McPhillamys Gold Project: Adequacy of Environmental Assessment

I refer to the correspondence dated 9 September 2019 inviting the Resources Regulator to provide advice regarding the adequacy of the McPhillamys Gold Project Environmental Impact Statement (dated 27 August 2019) for McPhillamys Gold Project.

The Resources Regulator advises the Department of Planning, Industry & Environment – Resources Assessments that the SEARs for Rehabilitation have not been adequately addressed in the McPhillamys Gold Project Environmental Impact Statement (dated 27 August 2019) for Project McPhillamys Gold Project, dated 9 September 2019.

Conceptual final landform cross sections: 1C and 2

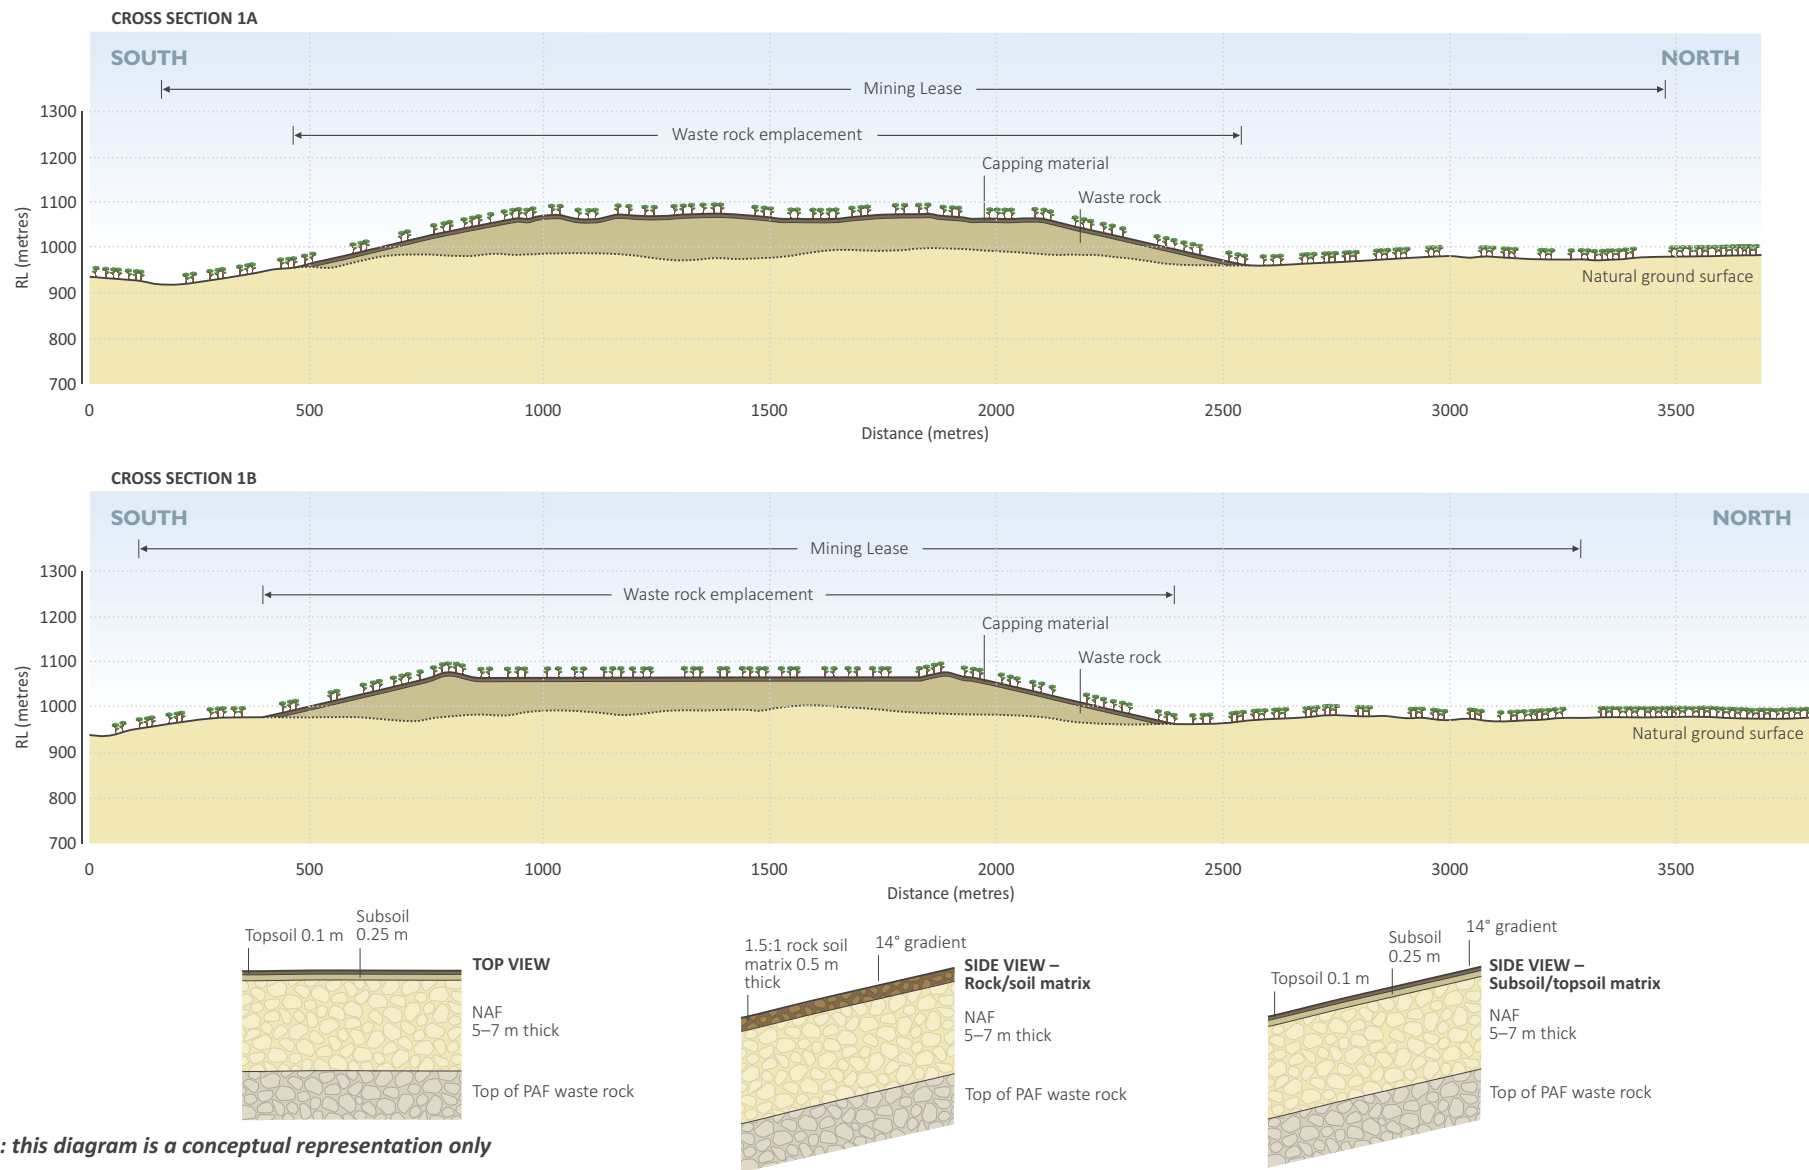
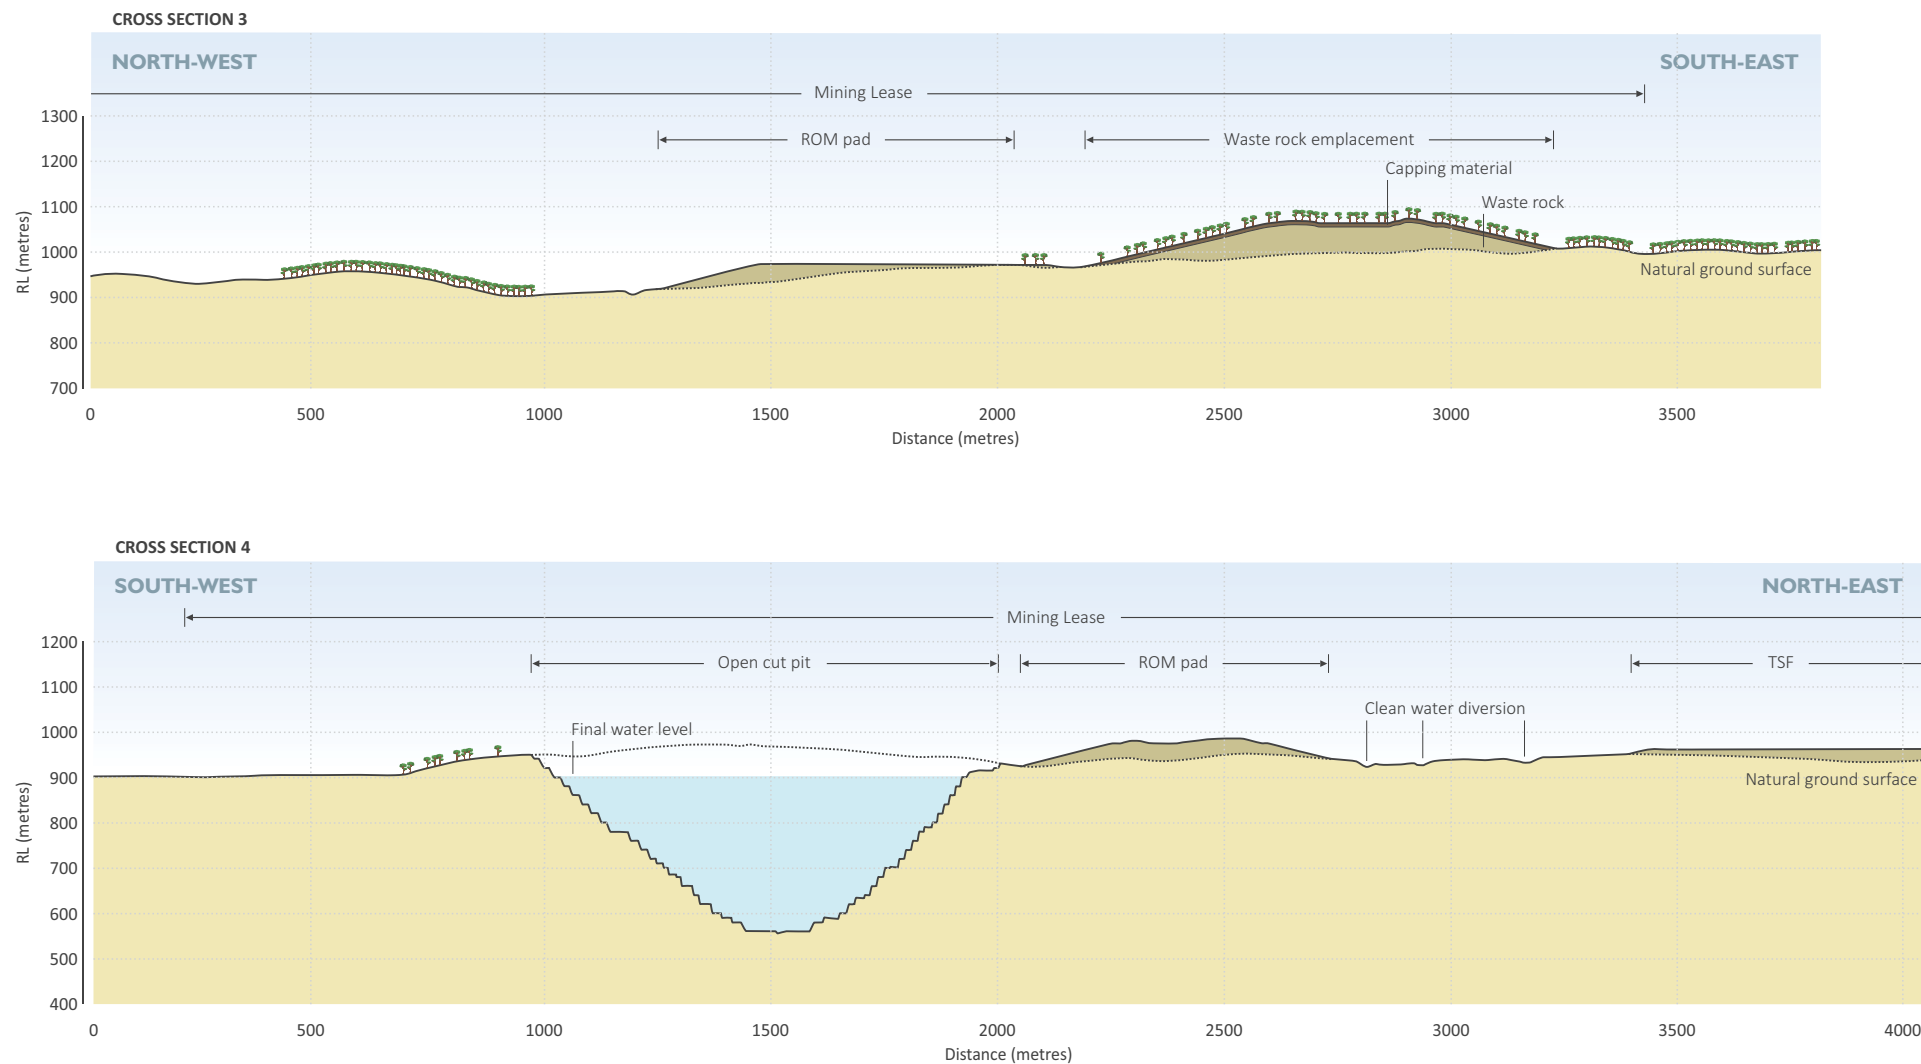
a) Figures provided in the EIS and Appendices do not provide an adequate level of detail for the TSF, WRE and ROM final landform. Provide drawings at an appropriate scale of the WRE and ROM final landform including, but not limited to, the following:

- i. Plan view
- ii. Section views, including reference to surrounding natural topography and any other proposed landforms or infrastructure.
- iii. Contours including labels (where appropriate)
- iv. Dimensions and slopes
- v. Structures and materials
